CITY OF ALBUQUERQUE

August 9, 2021

Re: Dions NM 22
9620 Universe Blvd NW
Traffic Circulation Layout
Architect's Stamp 08-03-2021 (B10-D003H)

TRAFFIC CIRCULATION LAYOUT
APPROVED
11/19/21
Date
Signed

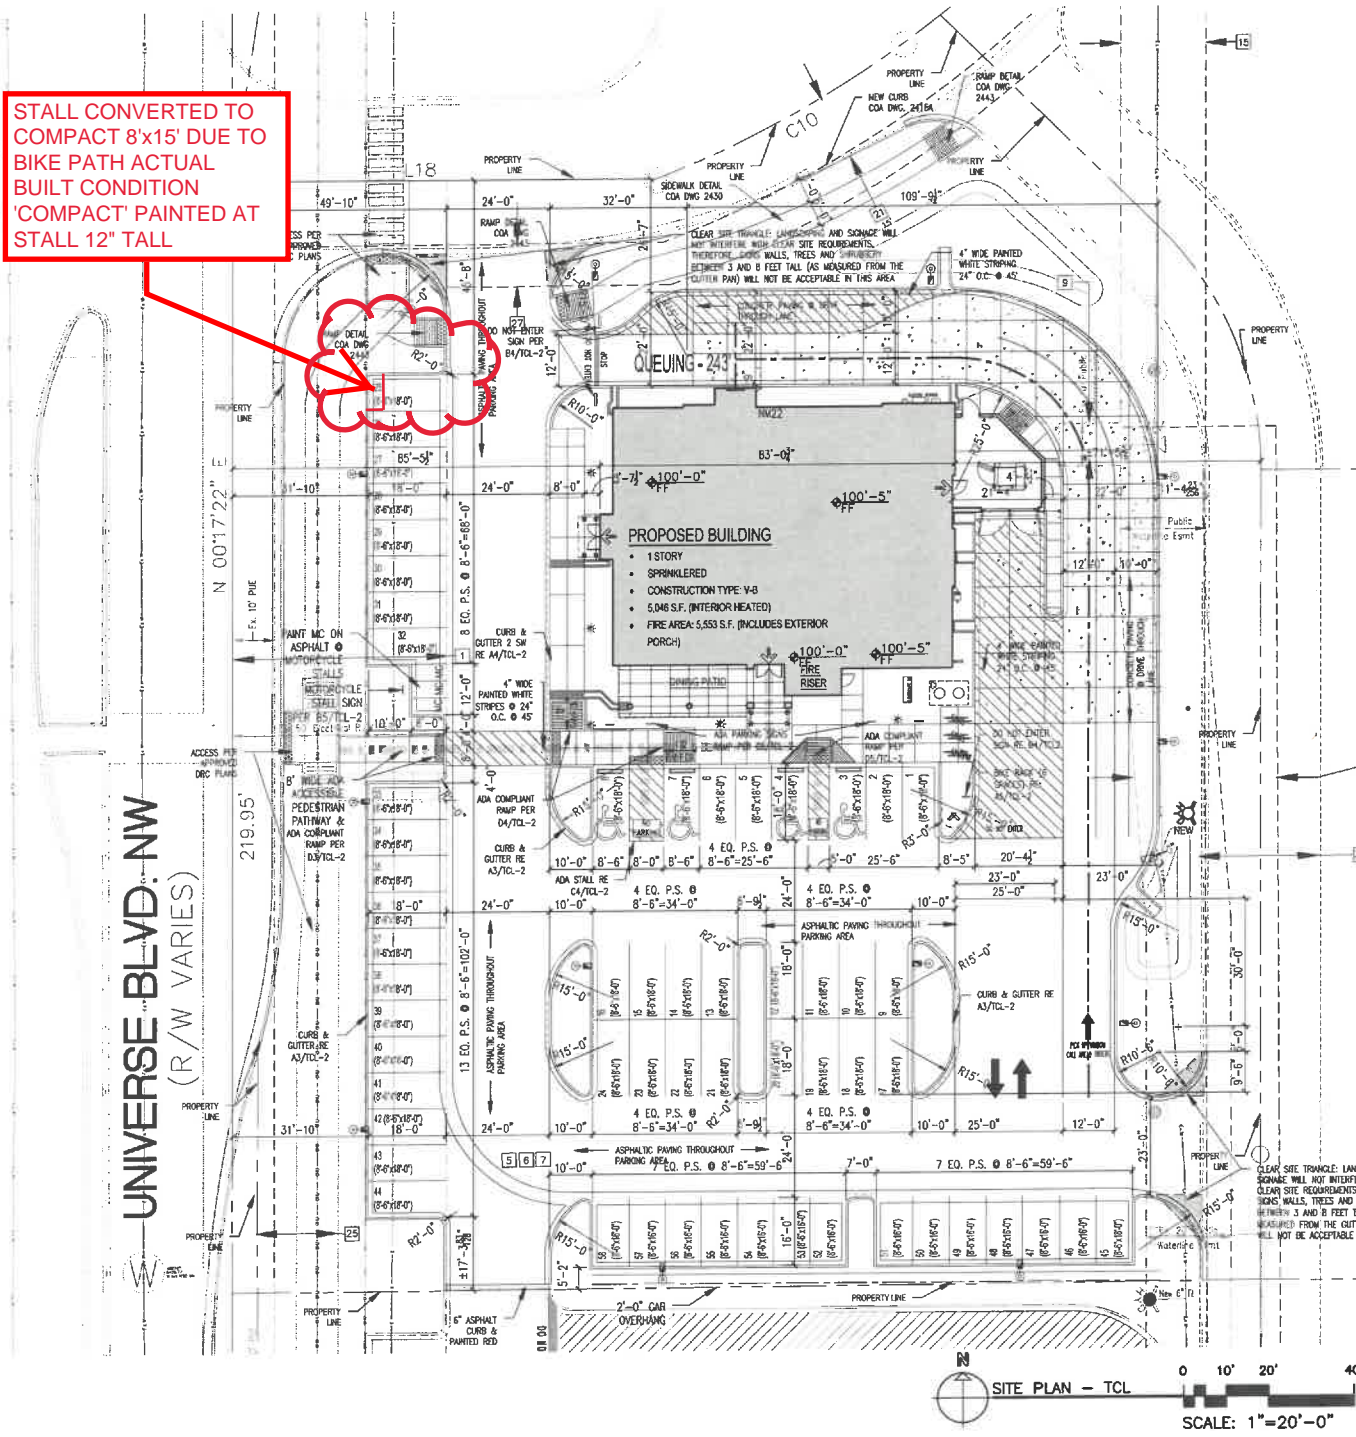
1. Listed are the number of parking spaces required by the IDO as well as the proposed number of parking spaces including bicycle and motorcycle parking.
Discuss/coordinate with Zoning.

2. Identify all existing access easements and rights of way width dimensions (**if applicable**).
3. Identify the right of way width, medians, curb cuts, and street widths on **Universe Blvd.**

4. Clarify existing property lines and proposed property lines. **Show all of the property line around the perimeter of the lot/track.**
5. **Their appears to be an auxiliary access road on the eastside of proposed development.** Please provide construction notes on this roadway infrastructure and include details of pavement design. The roadway will need to be a minimum of 24 ft for 2 way traffic flow unless the whole width is larger than 24 ft and will be constructed at present time. Include limits of the auxiliary access road for proposed development.

6. Any proposed onsite infrastructure like **curbing will need to be labeled and detail provided.**
7. Provide construction notes at both access points to the existing **primary Access Road.** Include details for **drive aisle entrance infrastructure and auxiliary access road.**

8. **Pavement markings:** Details will be needed for all pavement markings/stripping.
9. At the southern end of drive aisle adjacent to southern lot/tracker, a traffic control device will be needed to alert vehicles of open space.

10. Please list the width and length for all existing and proposed parking spaces. Some dimensions are not shown.
11. **The minimum parking stall dimensions are:**

12. Label the compact parking spaces by placing the words “**COMPACT**” on the pavement of each space.

- ADA curb ramps must be updated to current standards and have truncated domes installed as the access road entrance.
- The **existing ramp at corner of Universe/Access Road** doesn't line up with what appears to be sidewalk/asphalt trail connectons. Please clarify this concern.
- The **existing ramp and sidewalk** along the Universe Blvd frontage segment will need a **Sidewalk Easement** since its location is on private property.
- Will an ADA ramp be needed for existing median cut? **Explain situation.**

- **Will need to show sidewalk around the parameter of both these roadway as well as curb and gutter.**
- **ADA ramp needs to be shown at end of proposed trail as Access Road and detail provide for this ramp.**
- **Provide a ADA ramp on Universe that lines up with existing median cut for pedestrian access onto proposed asphalt trail.**

15. Motorcycle parking spaces:**Label pavement MC.**

20. Show all drive aisle widths and radii. Some dimensions are not shown.

28. All one-way drives shall have **"One Way" and "Do Not Enter" SIGNAGE** and pavement markings. Please show detail and **location of posted signs** and striping.

29. The minimum drive through lane width is 12 feet with a 25 foot minimum radius (inside edge) for all turns. (A 15 foot radius can be used with an increase in lane width to 14 feet). **Please dimension all lane widths and radii.**

A5 BICYCLE RACK
1/2"=1'-0"

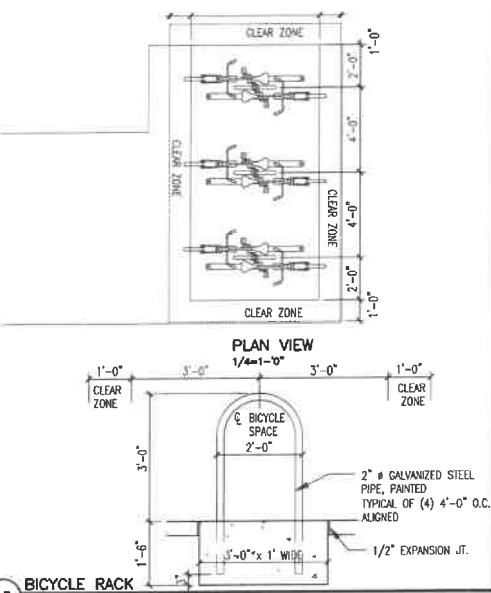
16. All bicycle racks shall be designed according to the following guidelines:

- a. The rack shall be a minimum 30 inches tall and 18 inches wide.
- b. The bicycle frame shall be supported horizontally at two or more places. Comb/toaster racks are not allowed.
- c. The rack shall be designed to support the bicycle in an upright position. See the IDO for additional information.
- d. The rack allows varying bicycle frame sizes and styles to be attached.
- e. The user is not required to lift the bicycle onto the bicycle rack.
- f. Each bicycle parking space is accessible without moving another bicycle.

17. Bicycle racks shall be sturdy and anchored to a concrete pad.

18. A 1-foot clear zone around the bicycle parking stall shall be provided.

19. Bicycle parking spaces shall be at least 6 feet long and 2 feet wide.
